5 April 2013

Ms Emma Barnett
Department of Planning and Infrastructure
GPO Box 39
SYDNEY NSW 2001

**Re: Materials Recycling Facility – Moorebank (05_0157)
Exhibition of Environmental Assessment**

FIGURE 4: FUTURE TRAFFIC DISTRIBUTION

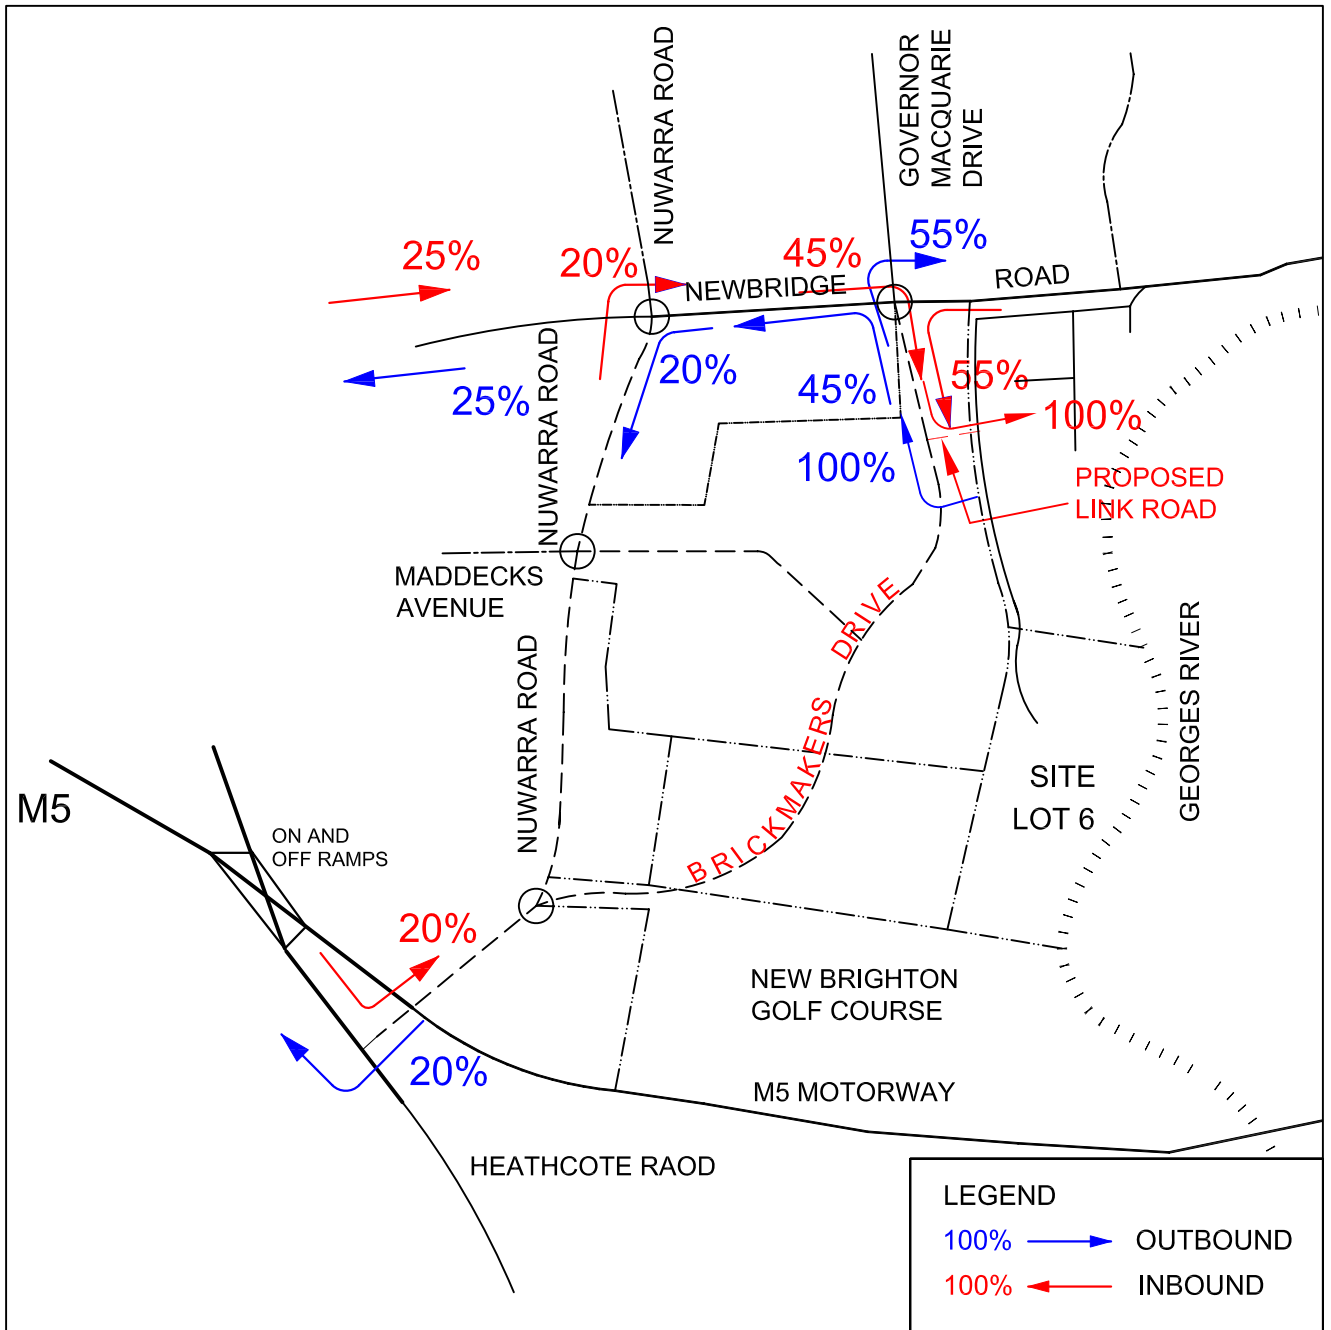
The directional distribution of trucks to the road network has been detailed within the report, with estimated proportion of movements relative to direction. It is considered that the figures used are merely theoretical as no further information had been detailed in respect to likely destinations. This deficiency was highlighted in Council's letter to the department dated 7 February 2013 and has not been addressed by the proponent prior to exhibition. Failure by the proponent to address these concerns suggests that further information would not have been of benefit to the applicant and raises further serious concerns regarding traffic flow.

- c) Governor Macquarie Drive - the adopted directional distribution of trucks excludes Governor Macquarie Drive. Council considers that a significant proportion of the trucks will use Governor Macquarie Drive to access the Hume Highway.

FIGURE 7
ESTIMATED PEAK HOUR (PCU'S) VOLUMES AT
BRICKMAKERS DRIVE/LINK ROAD INTERSECTION

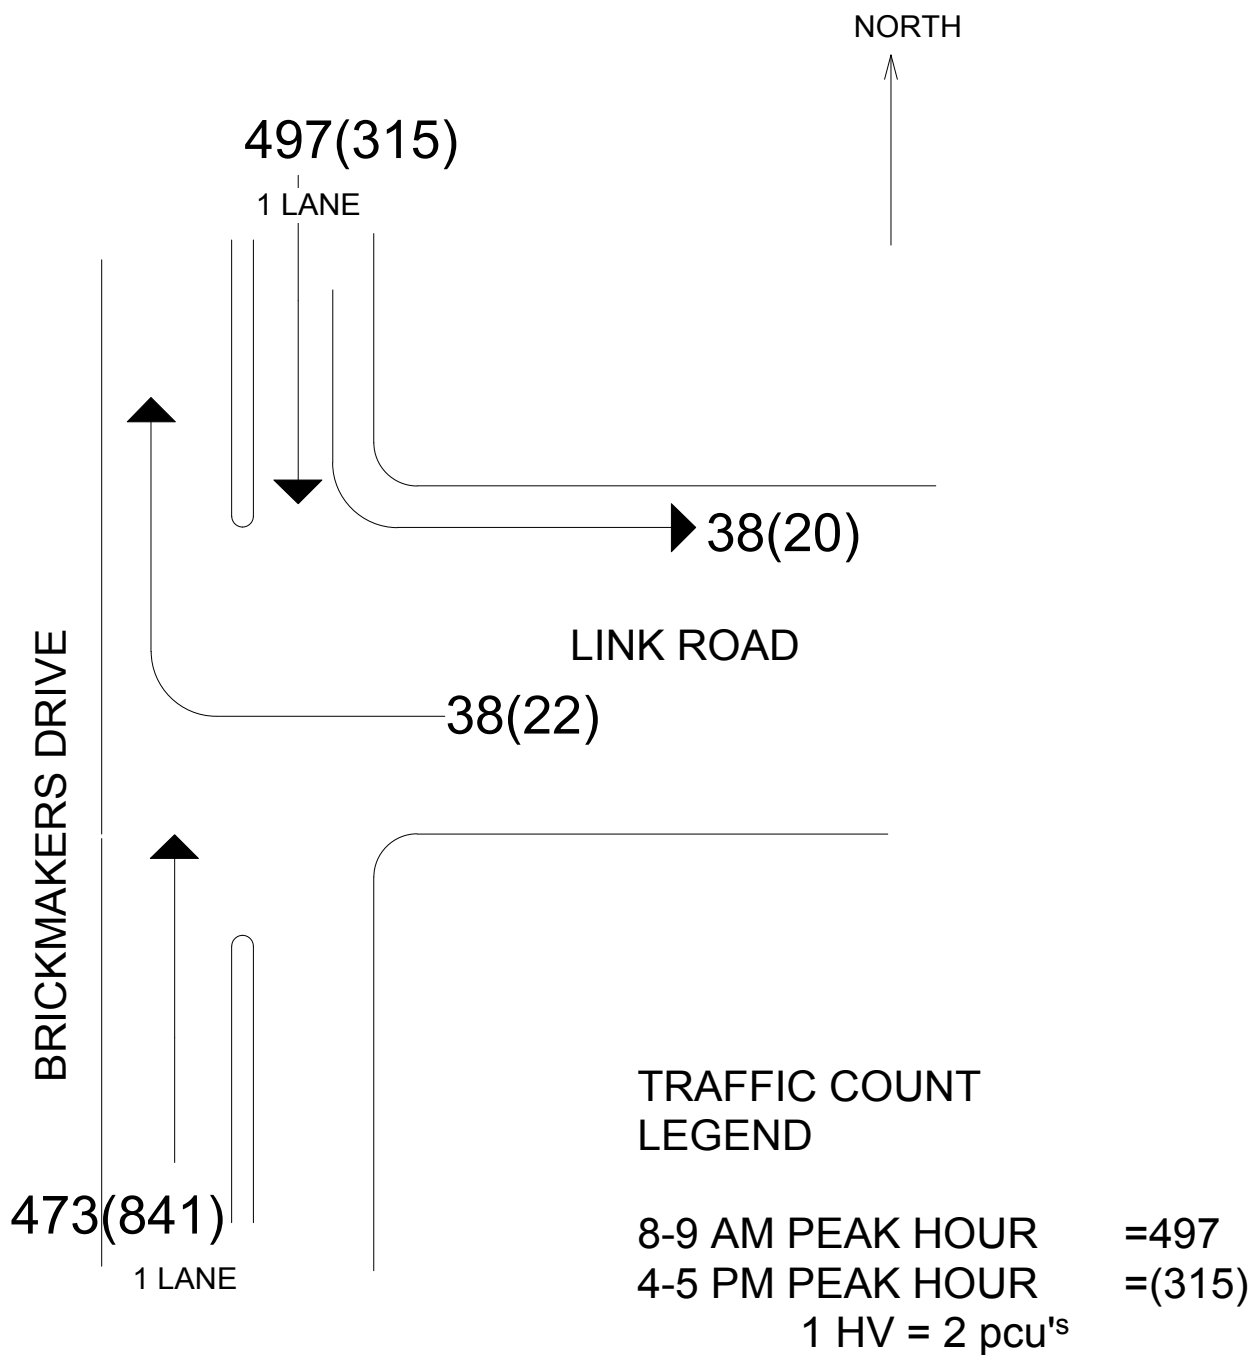
In its letter date 7 February 2013, Liverpool City Council noted that this assessment does not take into consideration the cumulative traffic impact of other proposed

developments that would use the link off Brickmakers Drive. This development is adjacent to the proposed marina at 146 Newbridge Road (DA-846/2012) and the residential development to the north of the subject site. Further there are enterprise corridor and additional retailing on 124 Newbridge Road that will be accessed from this point. It is intended that all three developments will use the proposed link road. Table 10-3 of the environmental assessment calculates the number of traffic movements in 2021 resulting from full development of Georges Fair. It fails to account for future developments such as the residential development north of the subject site (Figure 1) and the proposed marina.

Council previously suggested that a cumulative traffic assessment be prepared in consultation with the two other developers to best reflect development outcomes and traffic volumes. The Council could then be provided with a statement agreeable to all parties identifying the type of intersection to be provided, the design of the access road, and any required upgrades of the Brickmakers Drive intersections at Nuwarra Road and Newbridge Road to accommodate the developments. Such a report has not been forthcoming by the proponent.

Therefore, the traffic assessment and the intersection performance analysis of the proposal should therefore take into the consideration the cumulative traffic impact of the three proposed developments that will use the road link. This will allow the determination of the most appropriate intersection treatment to accommodate all vehicles that will use the proposed intersection. In this regard an intersection with Give Way control is considered unacceptable in the medium term.

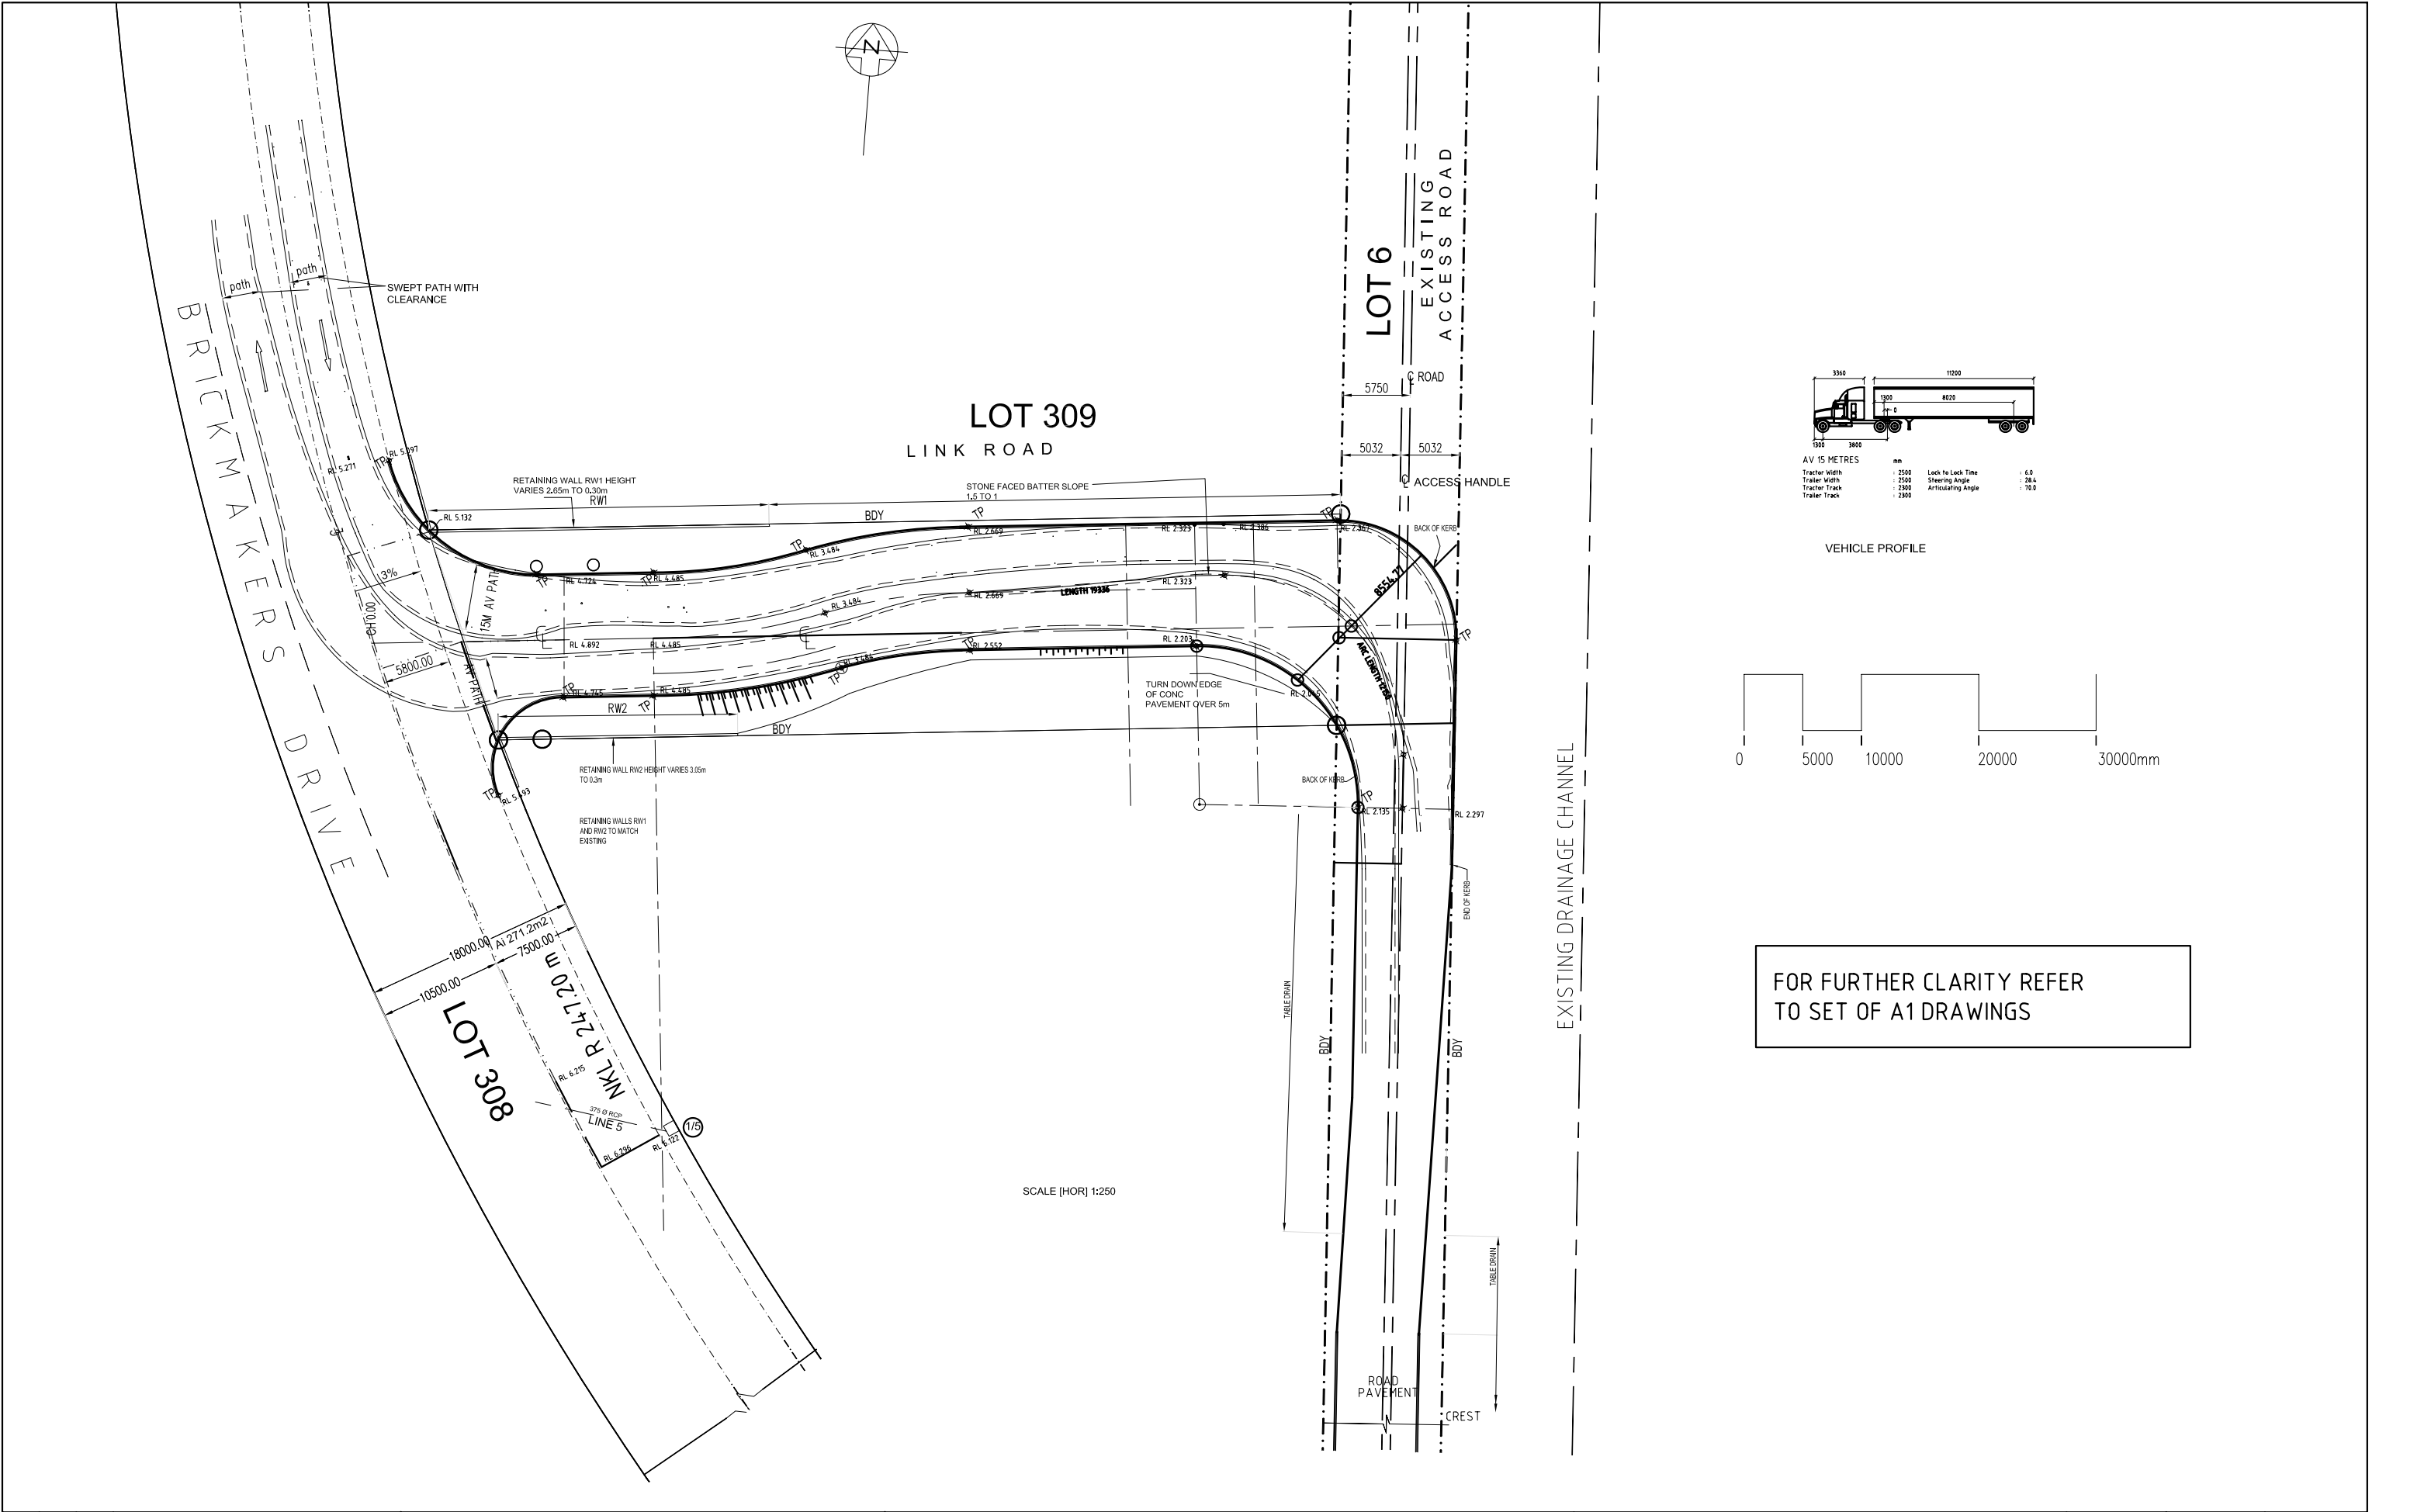
- b) Nuwarra Road - due to the uncertainty associated with the estimated increases in traffic volumes and the vastly over-estimated design traffic in Nuwarra Road, the impact of the additional heavy vehicles cannot be assumed to be *"low enough to be ignored."* From Council's previous investigations, it is clear that the majority of Nuwarra Road is significantly under-strength for the existing traffic loading and consequently large sections of the pavement are already in poor condition. Any increase in the number of heavy vehicles is certain to have a detrimental effect on pavement condition and accelerate demand for maintenance funding.
